Date: 30 March 2023
Our ref: 422565
Your ref: EN010133

NSIP Reference: EN010133

Natural England's comments in respect of Cottam Solar Project

Natural England's Relevant Representations

Figure 8.16.10: Landscape and Ecology Mitigation and Enhancement Plan – Cottam 3A Revision A

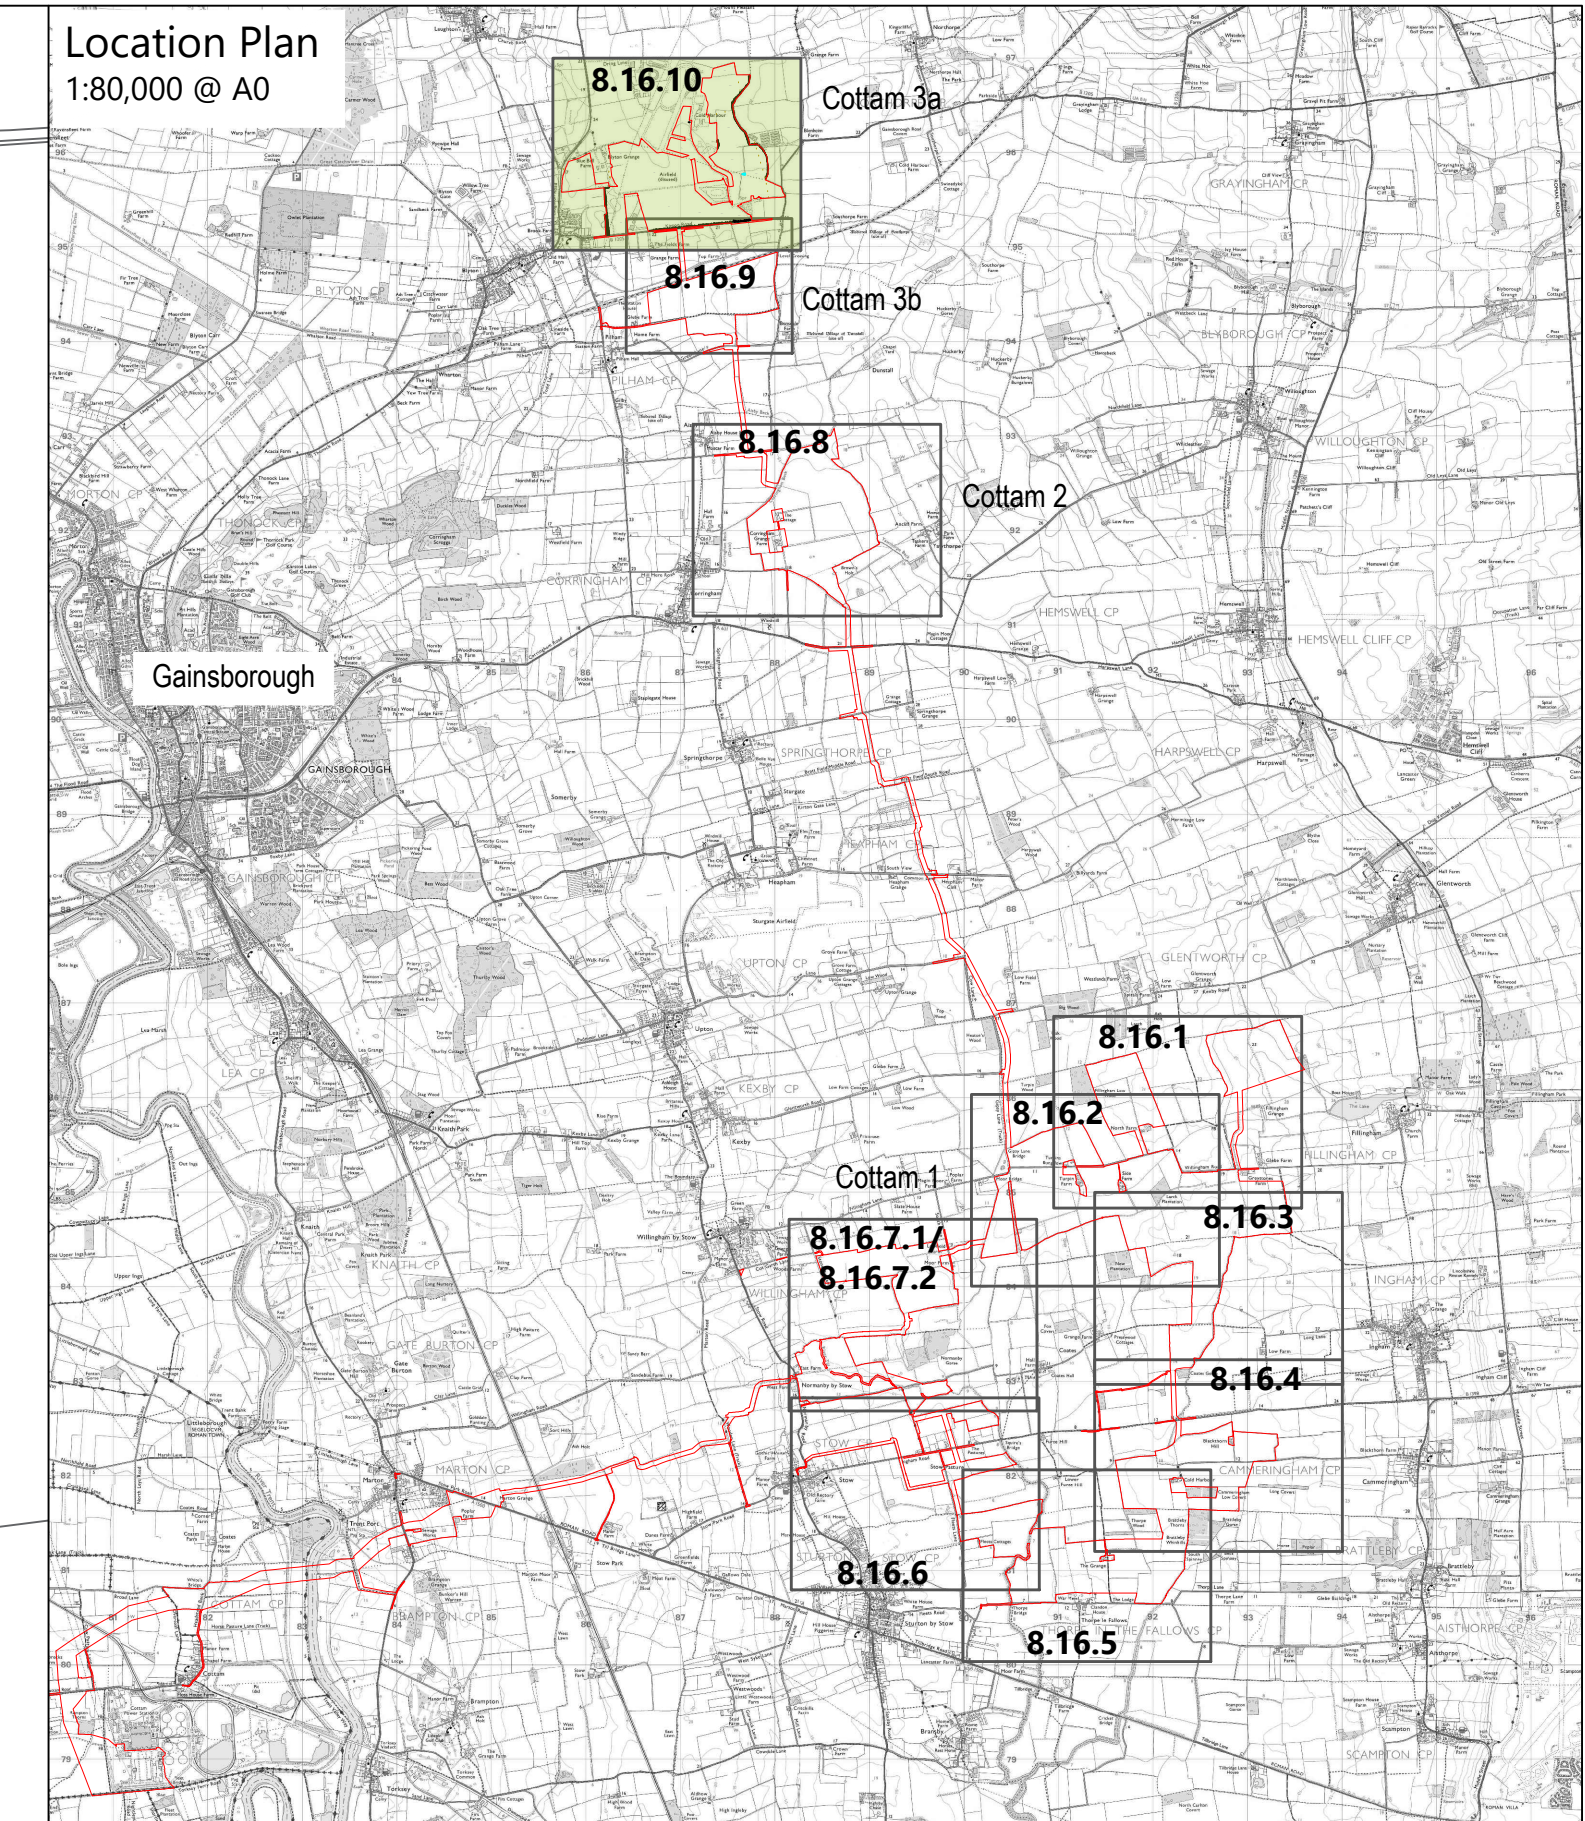
- Overall, Natural England welcome the biodiversity enhancement proposals, illustrated in the Landscape and Ecology Mitigation and Enhancement Plans (ES figures 8.16.1 to 8.16.10) which include a variety of habitats complimentary to the local environment.
